Subject: RE: Planning Re-Consultation on: BN/98/21/DOC

Thank you for reconsulting us. We have the following comments on conditions 10 and 11.

Condition 10

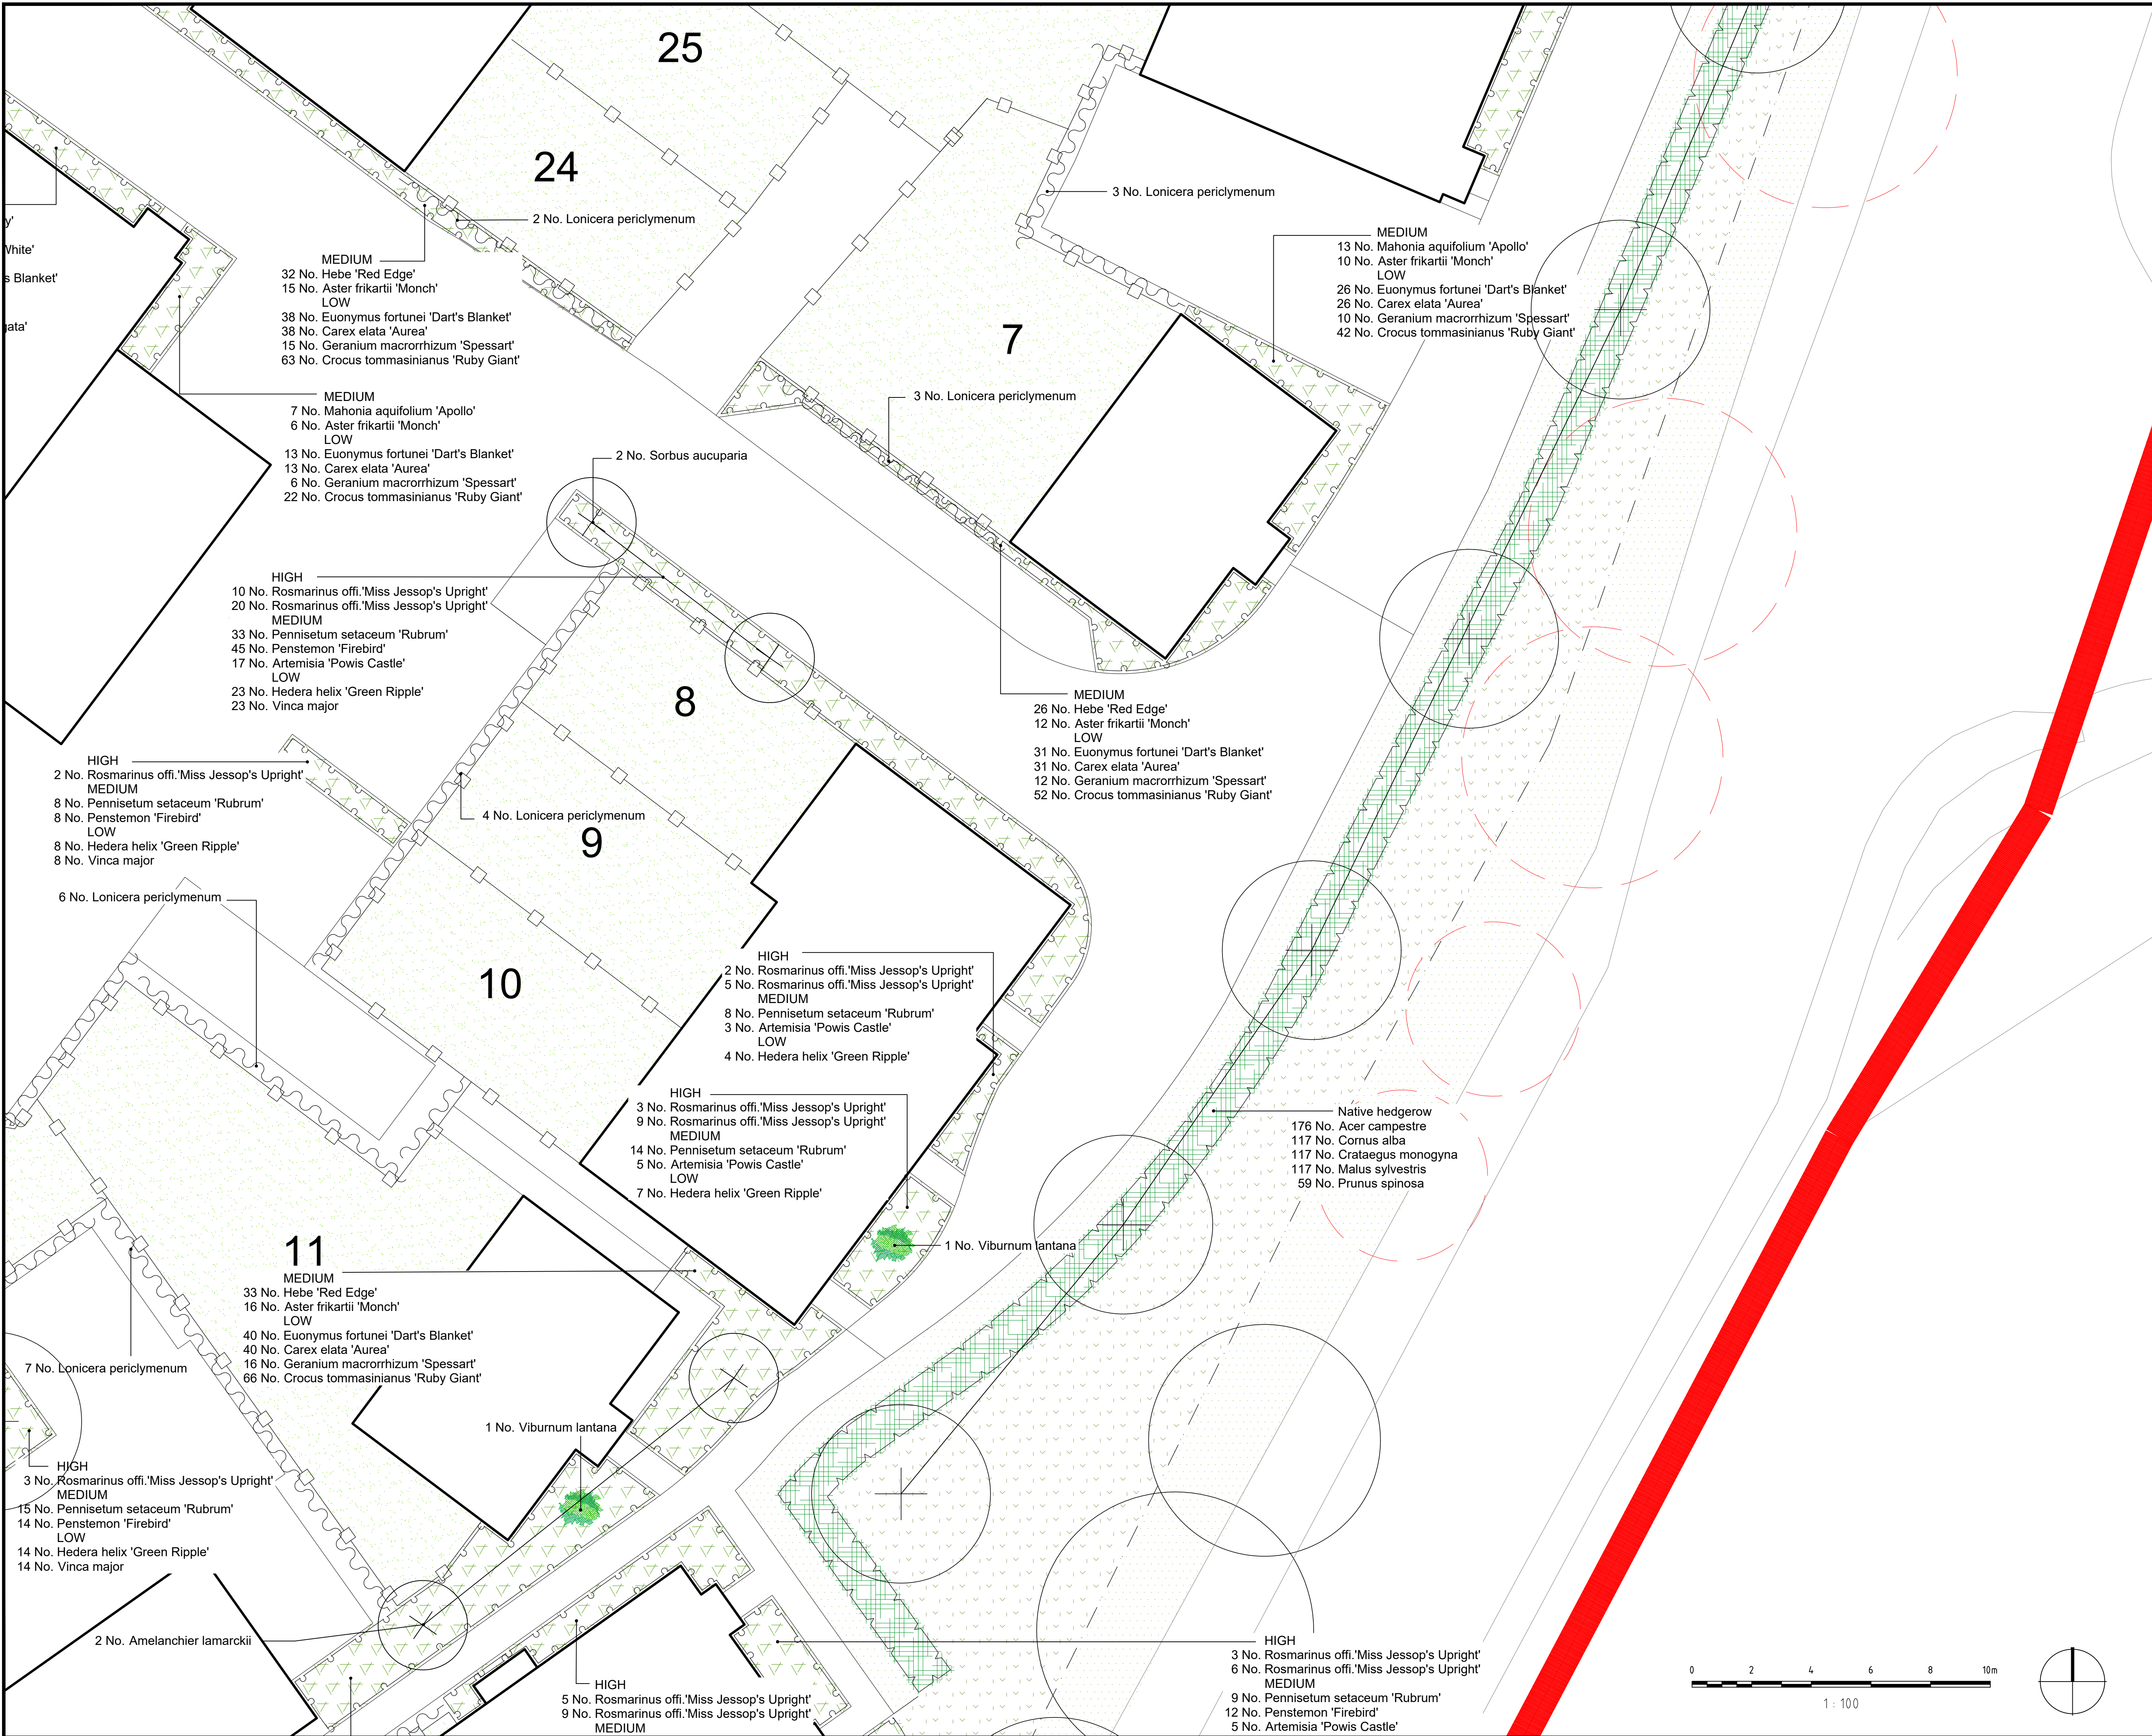
15. There is still conflict between planting plans and drainage layouts, i.e. trees over/ very close to infiltration crates.
16. Please re-consult Porstmouth Water regarding condition 10 now that proposals have crates as low as 2.57m depth.
